**RE: Lot 22-A-1
Grading and Drainage Plan
Engineers Stamp Date 11/16/16 (L19D074)**

From: Rael, Rudy E.
Sent: Wednesday, November 16, 2016 10:24 AM
To: 'tecnm@yahoo.com'
Cc: Carrillo, Abiel X.
Subject: 407 Mesilla St SE

Based upon the information provided in your submittal received 11/3/16, the above referenced Grading and Drainage plan dated 11/2/16 cannot be approved for Grading Permit or Building Permit until the following comments are addressed:

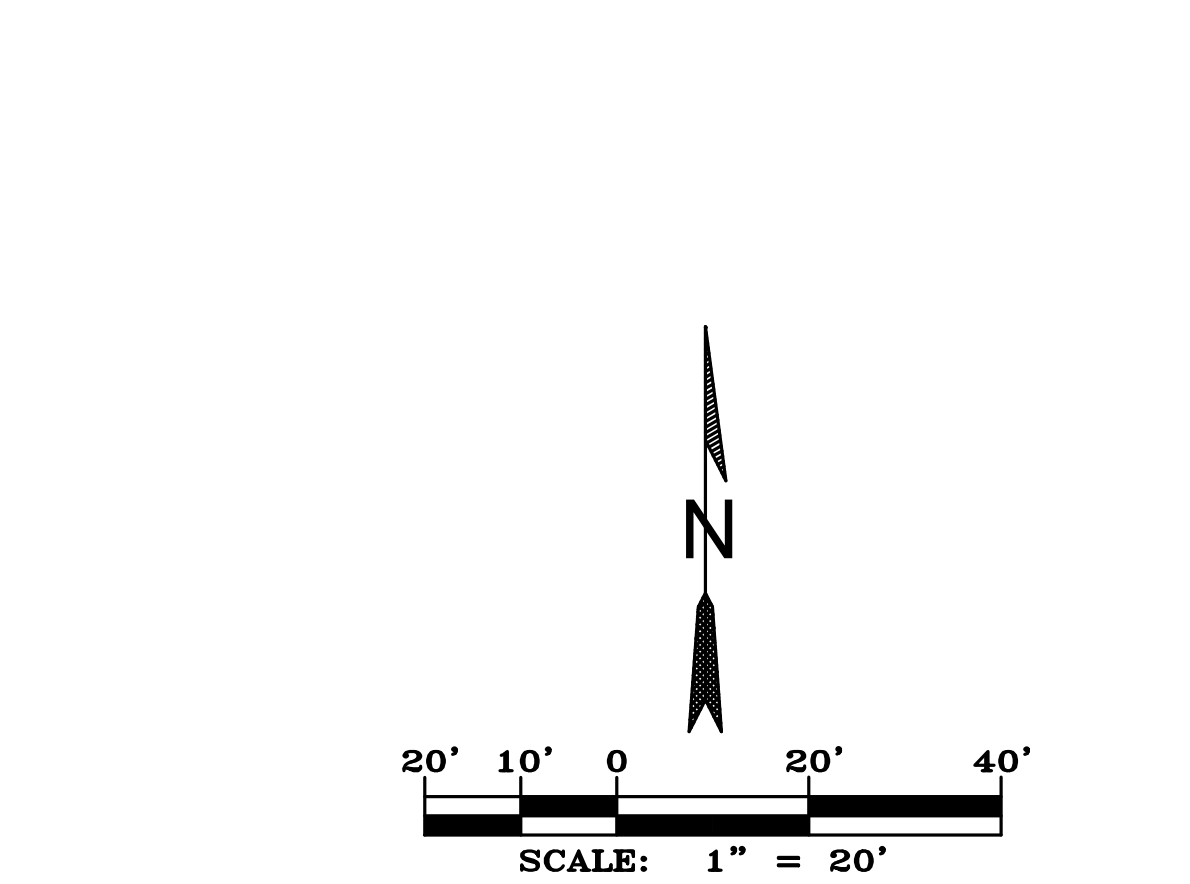
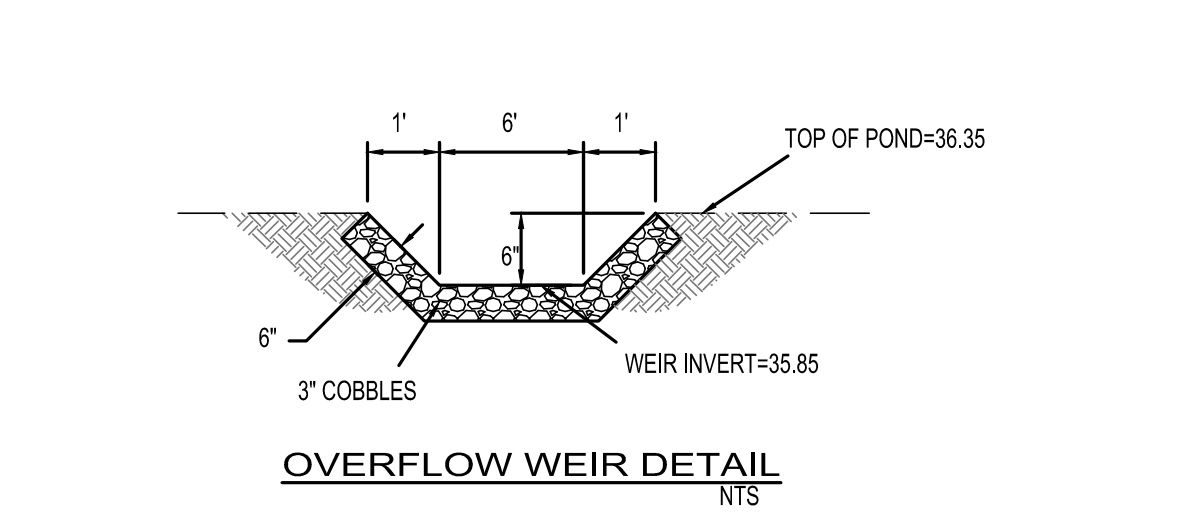
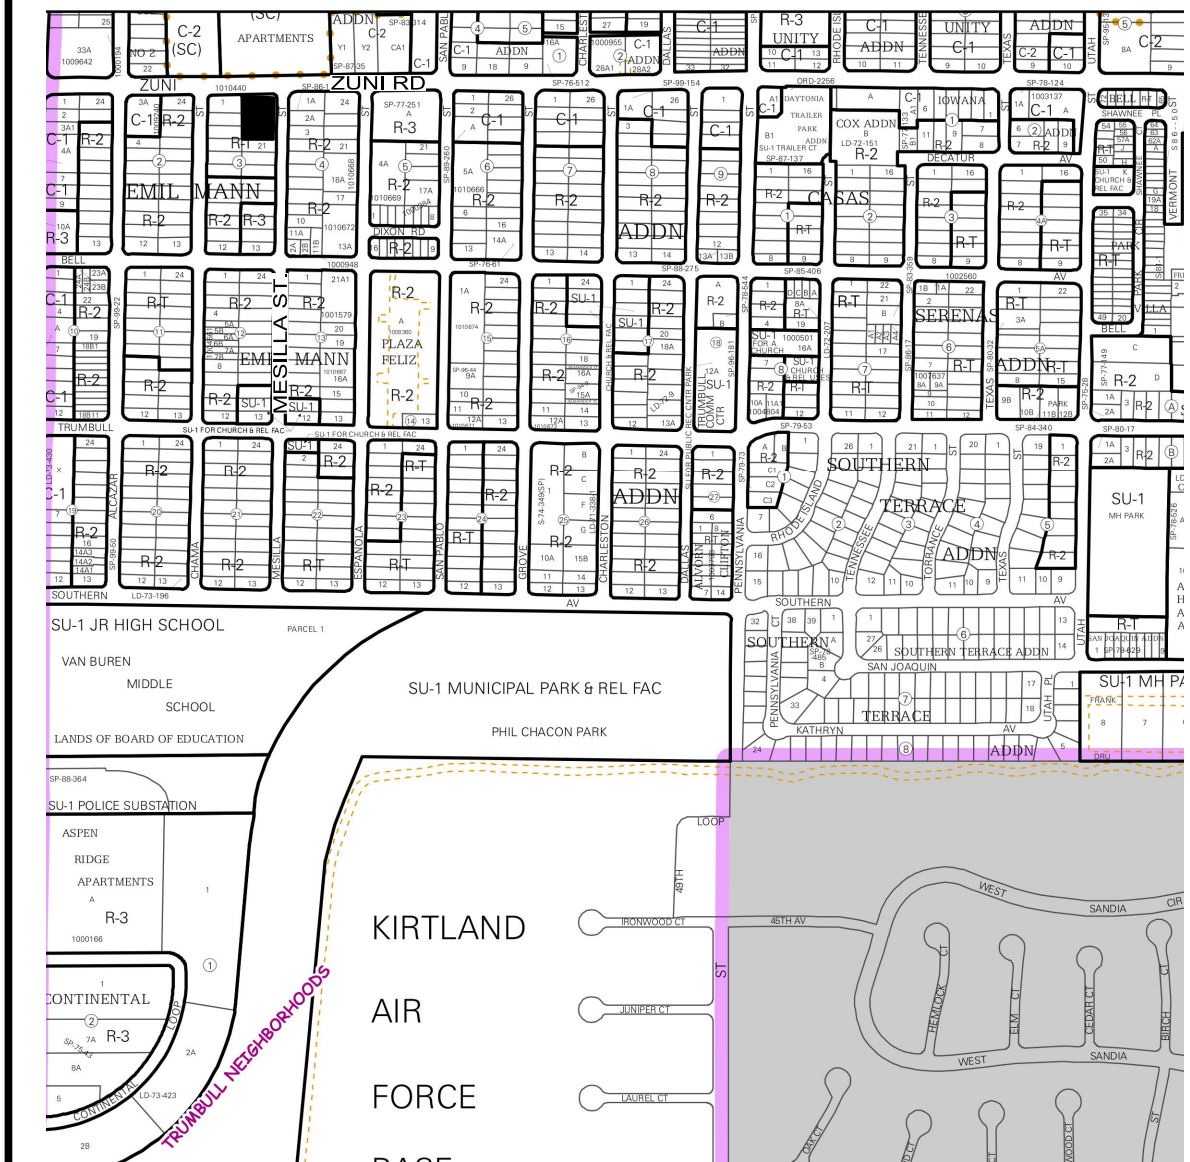
- Raise the weir by 4", enlarge the weir by 4' per our conversation on 11/16/16.
- Provide a detail of the swale.
- Provide a spot elevation on the sidewalk where the overflow from pond A to pond B is located.
- Provide a statement concerning any future fence must show an opening where the weir and the swale overflow.
